**RE: Transmittal of Comments – Cabin Mountain Tree Farm Tracts Large Lot (LL-08-06)
Cabin Mountain Tracts Large Lot (LL-08-07)**

To: Trudie Pettit, Staff Planner
From: Michelle Geiger, Plans Examiner Kittitas County Community Development Services
Date: May 30, 2008
Re: Cabin Mountain Tree Farm Tracts Large Lot, LL-08-06 & Cabin Mountain Tracts Large Lot, LL-08-07

TO: Trudie Pettit, Community Development Services
FROM: Randy Carbary, Planner II *RC*
DATE: May 7, 2008
SUBJECT: Cabin Mountain Tracts Large Lot Subdivision LL-08-00007

TO: Trudie Pettit, Community Development Services
FROM: Randy Carbary, Planner II *RC*
DATE: May 30, 2008
SUBJECT: Cabin Mountain Tree Farm Tracts Large Lot Subdivision LL-08-00006

CABIN MOUNTAIN TREE FARM TRACTS LARGE LOT SUBDIVISION
 A PORTION OF SECTION 8, TOWNSHIP 20N., RANGE 13E., W.M.
 KITTITAS COUNTY, WASHINGTON

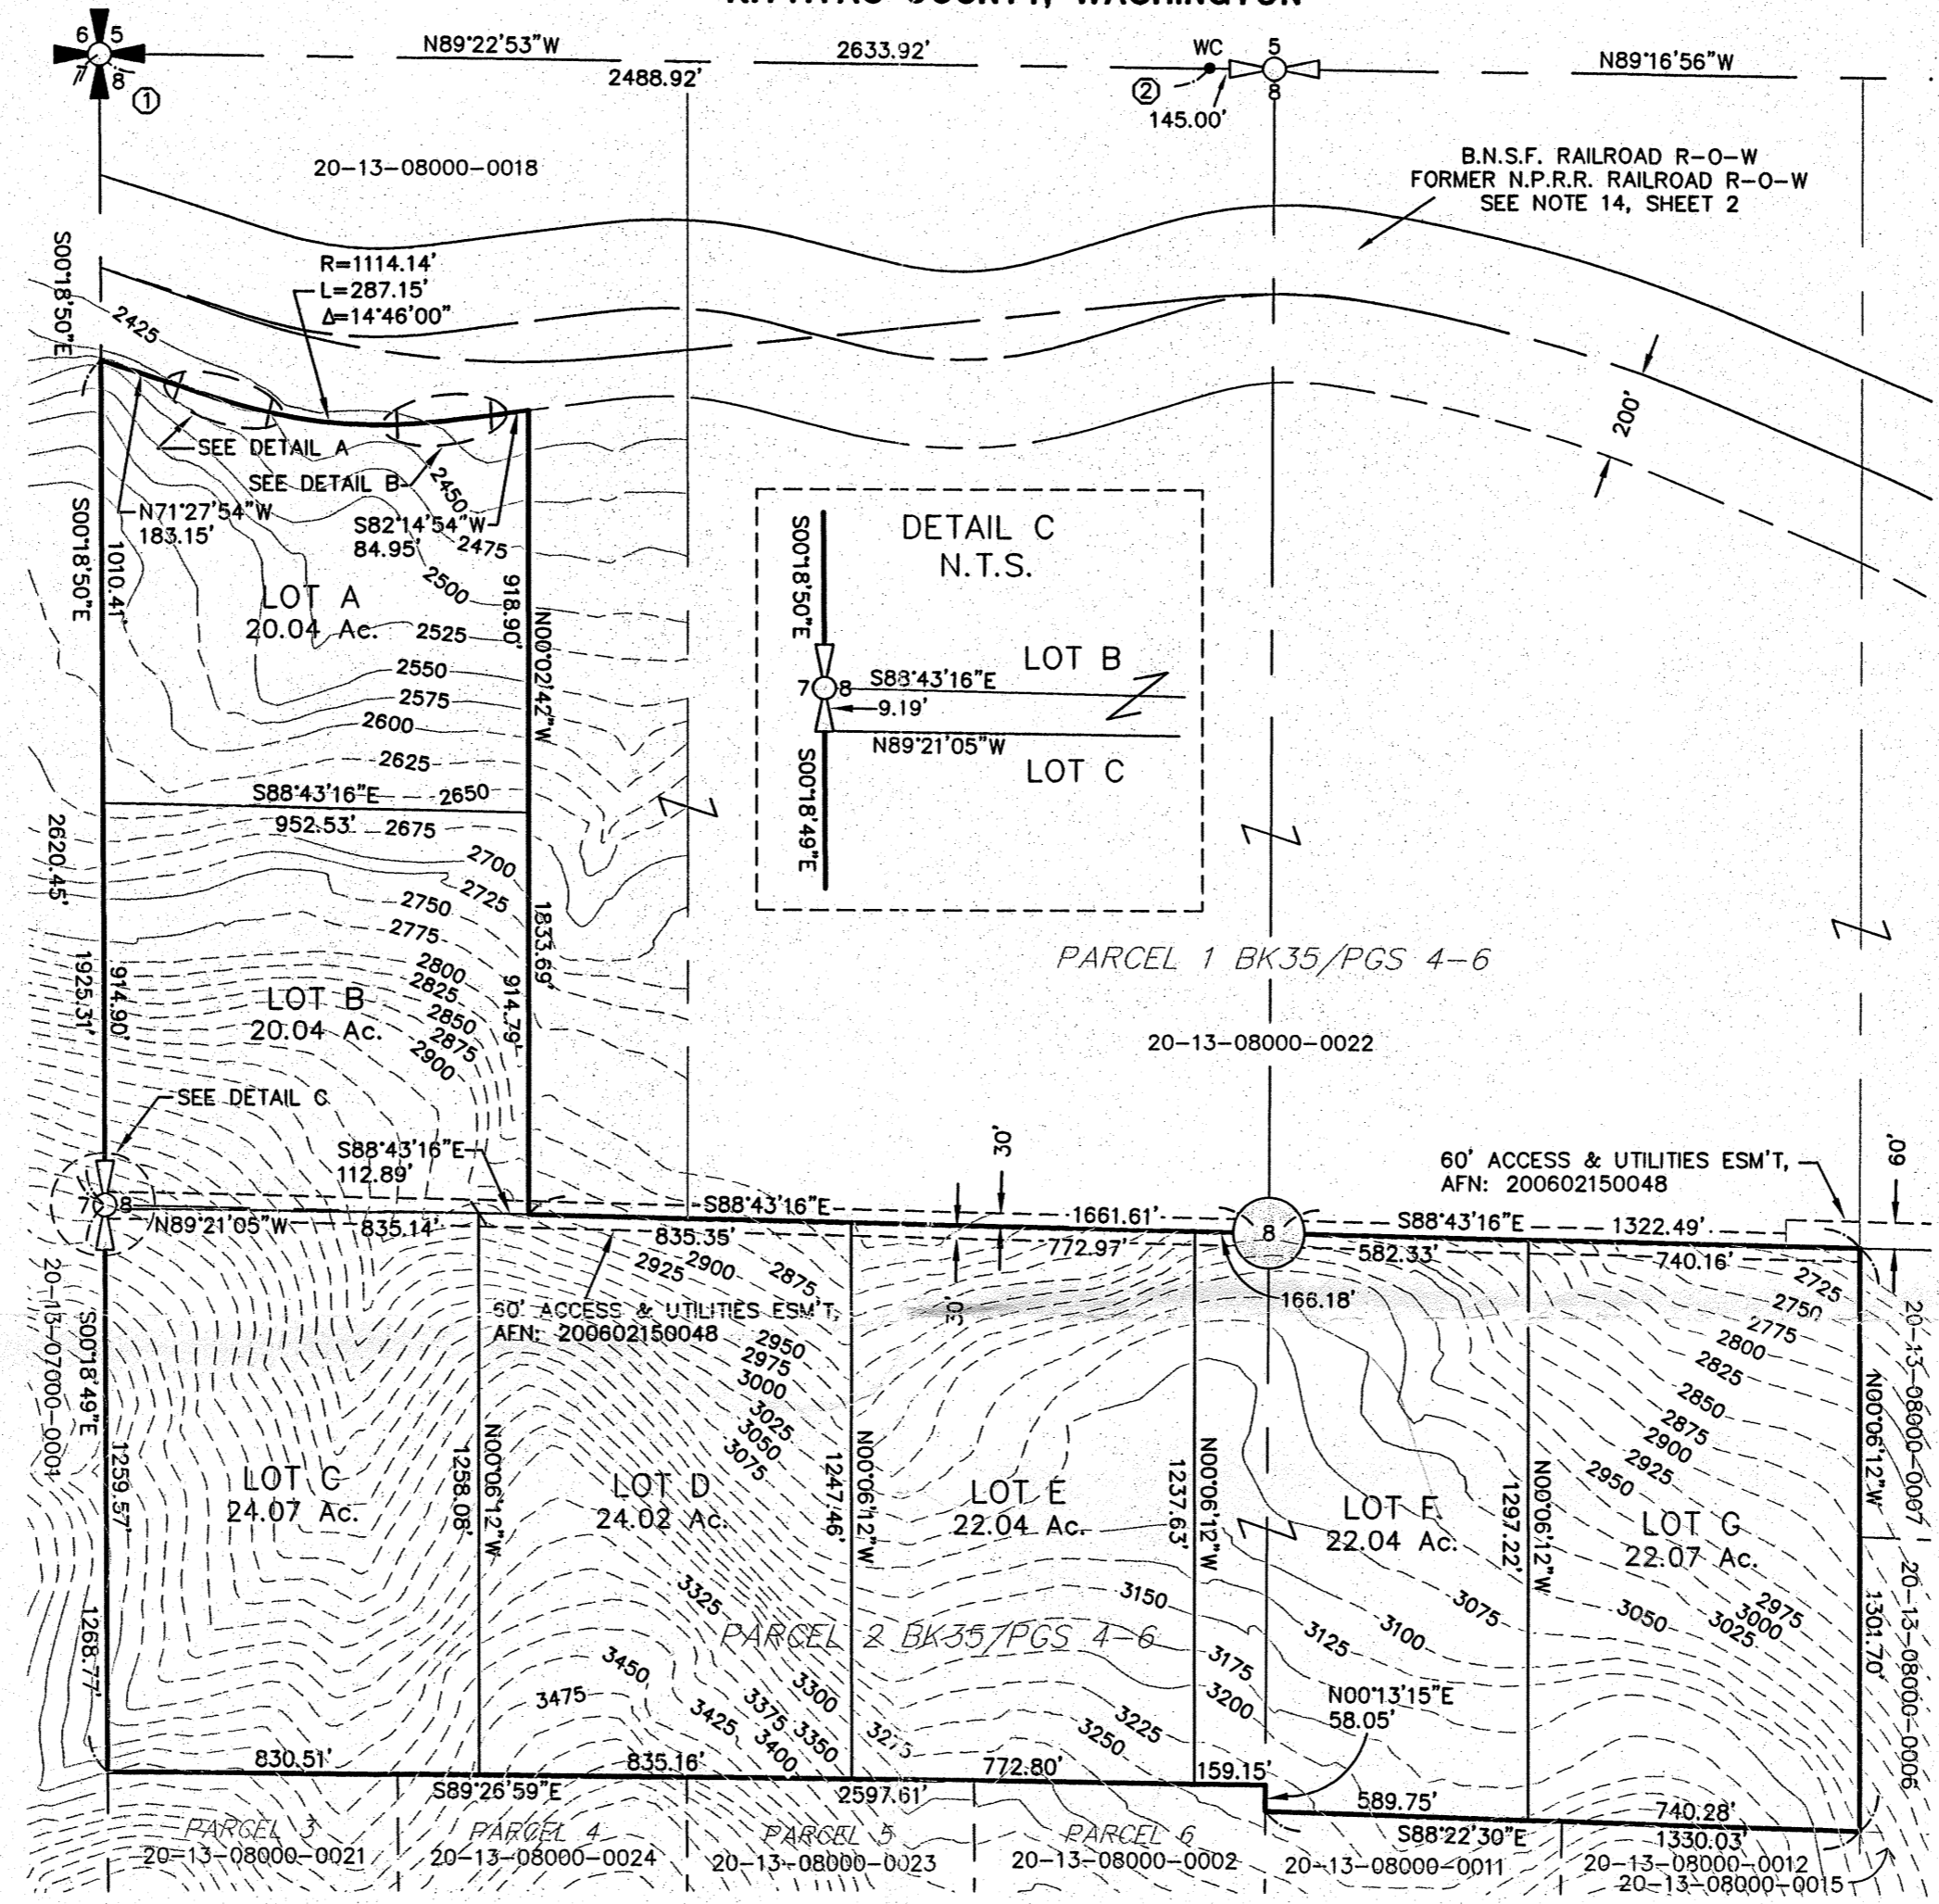
1. Access to Lot A Joint-Use Driveway: Access to lot A is not clearly depicted on the application. Access to lot A shall be via a joint-use access and shall serve no more than two tax parcels. Per Kittitas County Road Standards, 9/6/05 edition.

2. Cul-de-Sac: No cul-de-sac or turn around area is identified on the Large Lot Subdivision application. A cul-de-sac turn-around having an outside right-of-way easement diameter of at least 110 feet shall be constructed at the closed end of all dead-end roads serving 3 or more lots. The driving surface shall be at least 96 feet in diameter. Cul-de-sacs must also conform to the requirements specified by the 2006 International Fire Code. Contact the Fire Marshal regarding any additional cul-de-sac requirements.

4. Private Road Improvements: Access to lots A thru H shall be via the 60' Access and Utility Easement as depicted on the face of the plat. Access shall be constructed as a Low-Density Private Road. See Kittitas County Road Standards, 9/6/05 edition.

- a. Access easements shall be a minimum of 20’ wide. The roadway width shall have a minimum width of 12’.
 - b. The surface requirement is for a minimum gravel surface depth of 6”.

The location of the cul-de-sac or turn around area shall be depicted on the face of the Large Lot Subdivision application, prior to final approval of the Large Lot Subdivision., regardless of its location.

- a. Access easements shall be a minimum of 60' wide. The roadway shall have a minimum width of 20', with 1' shoulders, for a total width of 22'.
 - b. Minimum centerline radius will be 60'.

- c. The surface requirement is for a minimum gravel surface depth of 6".
 - d. Maximum grade is 12%.
 - e. Stopping site distance, reference AASHTO.
 - f. Entering site distance, reference AASHTO.
